# ONLINE CONSULTEE RESPONSE ON PLANNING APPLICATION 23/11033

Location	WILLOW COTTAGE, HIGH STREET, DAMERHAM SP6 3EU
Received Date	27 November 2023
Missing Information received from	NFDC Conservation

Drawing
Existing Elevations
+ Proposed.

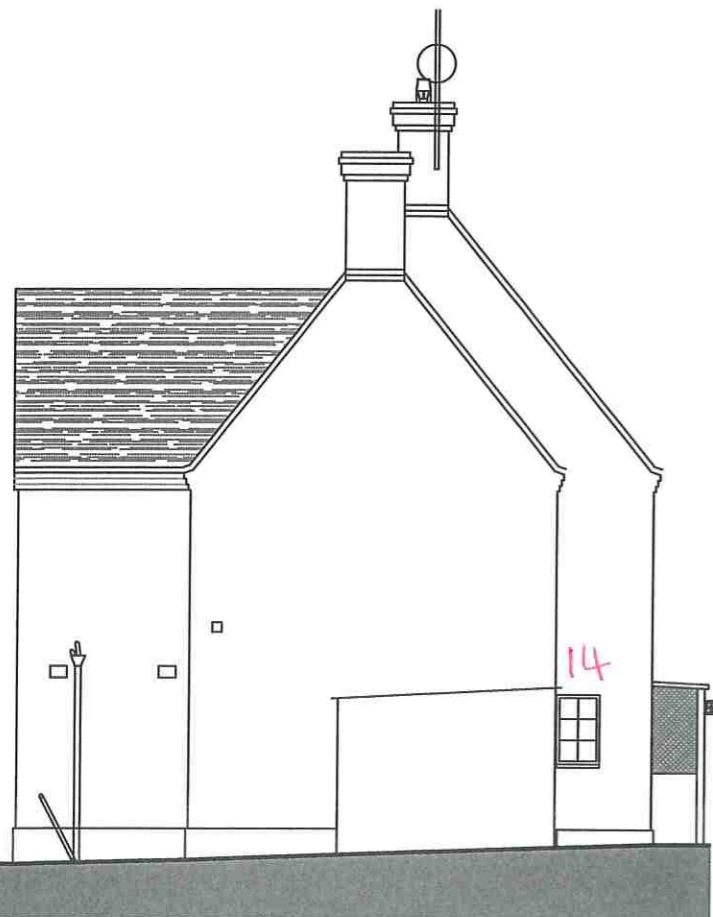
In this instance there is no window schedule or sufficiently detailed assessment of the existing windows that are proposed to be replaced in order to justify the proposed works.

Where such extensive and significant alterations such as the replacement of windows are proposed the application will need to be supported by a detailed photographic window schedule that;

- Clearly details the character of each window to which works are proposed and assess the windows contribution to the significance of the asset

- Where frames are to be replaced, evidences that the historic fabric is either;
  - beyond reasonable repair, or
  - its replacement is not consequential to the significance of the listed building.
